Your Reference Numbers: BC041001 and
TR051002

**ISSUE SPECIFIC HEARING THREE – EXAMINING PANEL ACTION POINTS
EAST MIDLANDS GATEWAY PHASE 2 (PLANNING INSPECTORATE REFERENCE: BC041001) AND
MATERIAL CHANGE ORDER TO THE EAST MIDLANDS GATEWAY RAIL FREIGHT INTERCHANGE AND
HIGHWAY ORDER 2016 (S.I. 2016/17) (PLANNING INSPECTORATE REFERENCE: TR051002).**

The responses from North West Leicestershire District Council ('NWLDC' – the Council) (Interested Party Reference Number ('IPRN') – FCB2E7A1E) in relation to the action points of the Examining Panel ('Exp') from Issue Specific Hearing 3 ('ISH3') are as follows.

Image 1: Example hibernacula

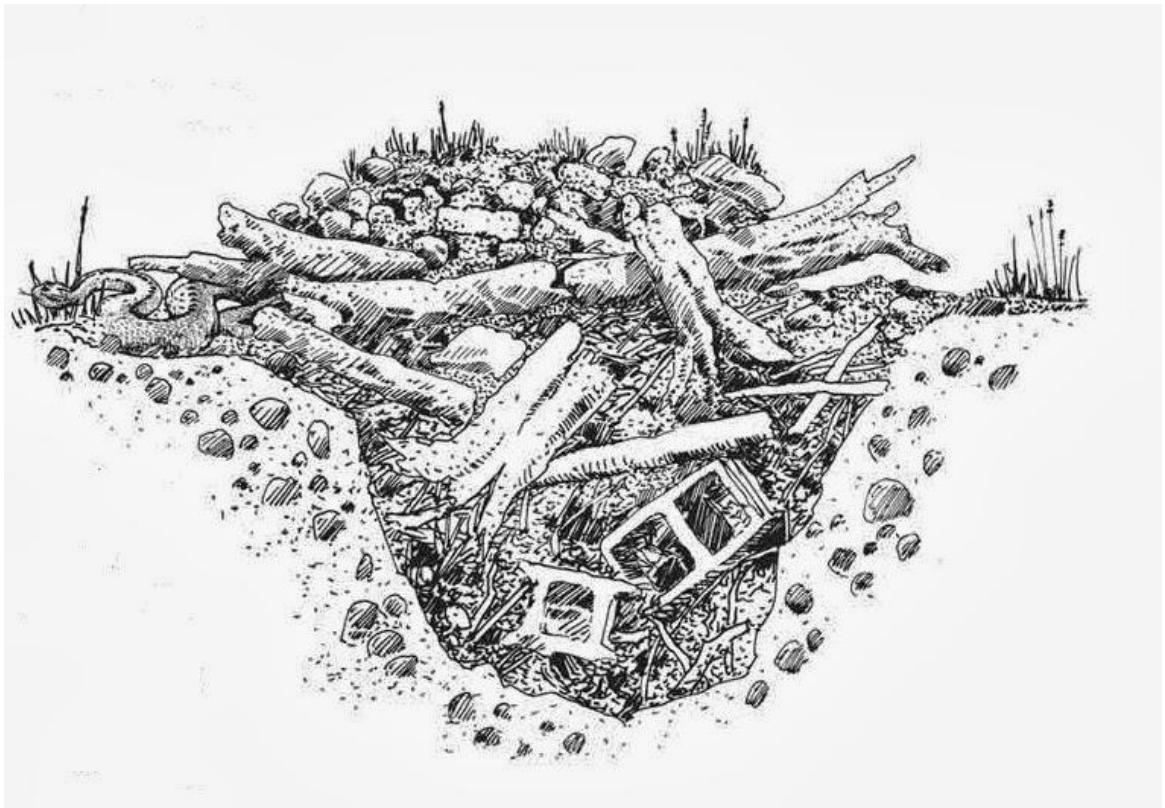
The only comment made by NWLDC that has not been addressed in the applicants' updated Landscape and Ecological Management Plan ('LEMP') is that, in the bullet points following paragraph 4.36 of the LEMP, Glyphosate is referred to as a contact herbicide when it is not. If the applicants mean to refer to a contact herbicide (i.e. one that kills off the leaves), then the example should be changed (e.g. Glufosinate or similar approved herbicide). If the applicants mean to refer to Glyphosate, then it should be referred to as a non-residential translocated or systemic herbicide (i.e. one that travels through the plant to the roots). These herbicides work in different ways. If the applicants did not want to be prescriptive, then NWLDC considers that the LEMP could instead refer to the following: "Spot treatment with a herbicide such as Glyphosate, or similar approved herbicide."

LCC, as the ecological advisors to NWLDC, has explained that they are also largely satisfied with the management regimes within the LEMP. The only concern that LCC has raised is in respect of the use of herbicides within and adjacent to the ponds, bioswale / Sustainable Drainage System ('SuDS') and ditches. In this respect, NWLDC notes that Section 4.78 specifically mentions controlling the use of herbicides within and adjacent to the stream to prevent pollution and / or adverse ecological effects. A similar statement is not made in relation to the ponds, bioswale / SuDS and ditches, but should be included in order to avoid any potential adverse effects.
